CITY OF ALBUQUERQUE

Re: PurLife
4320 Lead Ave. SE
Request for Certificate of Occupancy
Transportation Development Final Inspection
Engineer's/Architect's Stamp dated 01-26-2018 (K17D047)
Certification dated 11-01-18

1 SITE PLAN  
A-1 SCALE: 1/8" = 1'-0"

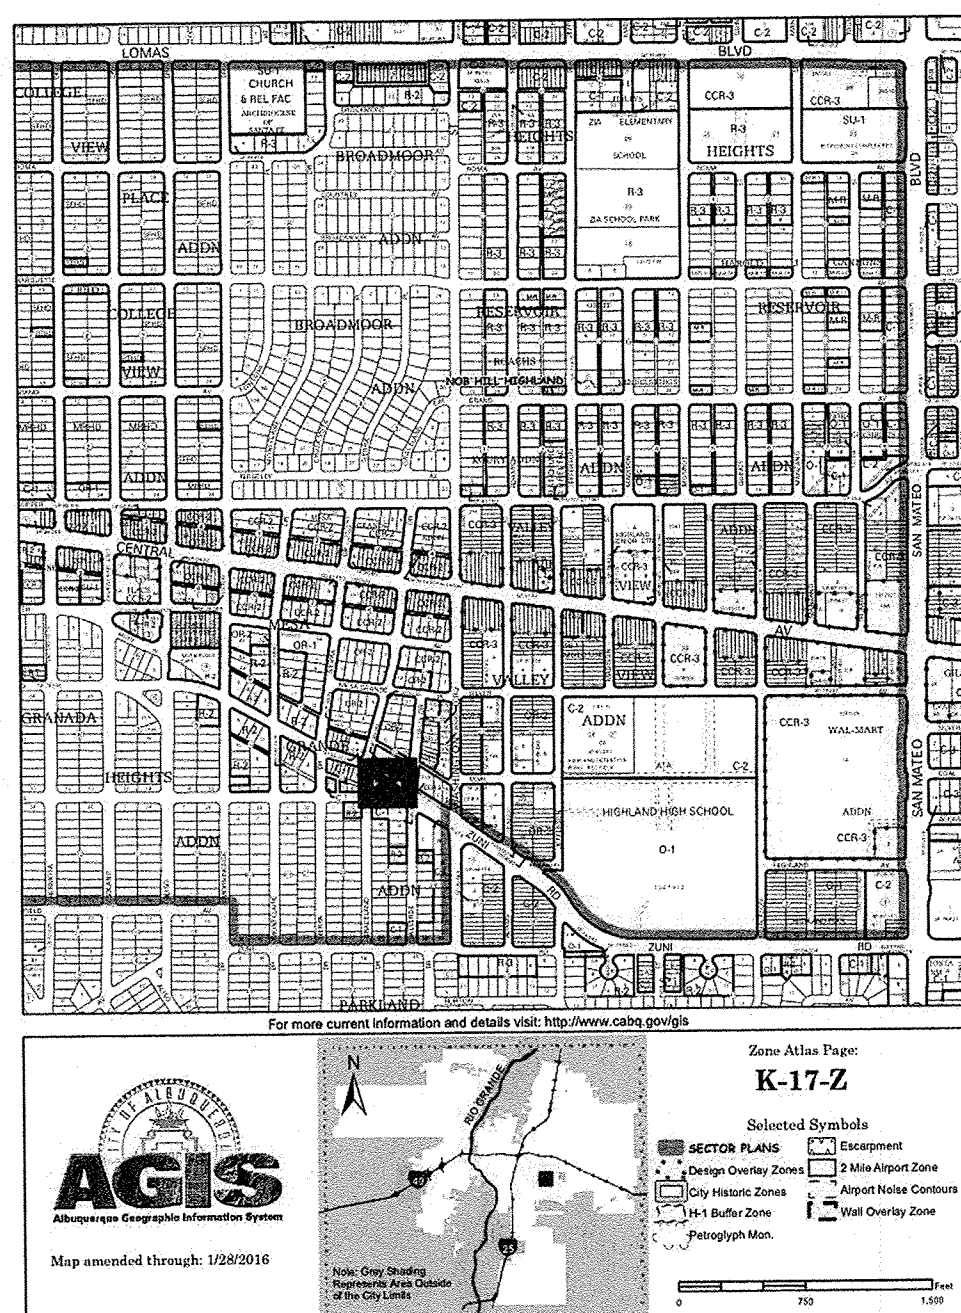
- The ADA marking on a Parking space which is not ADA should be removed.
- The motor cycle space should not have striping. Please remove the striping from the motor cycle space.
- This comment is not something to be addressed. Just note that on TCL, the name of the streets have been exchanged. The lead should be cole and vice versa. (we are fine with that, just for your own info for the future)
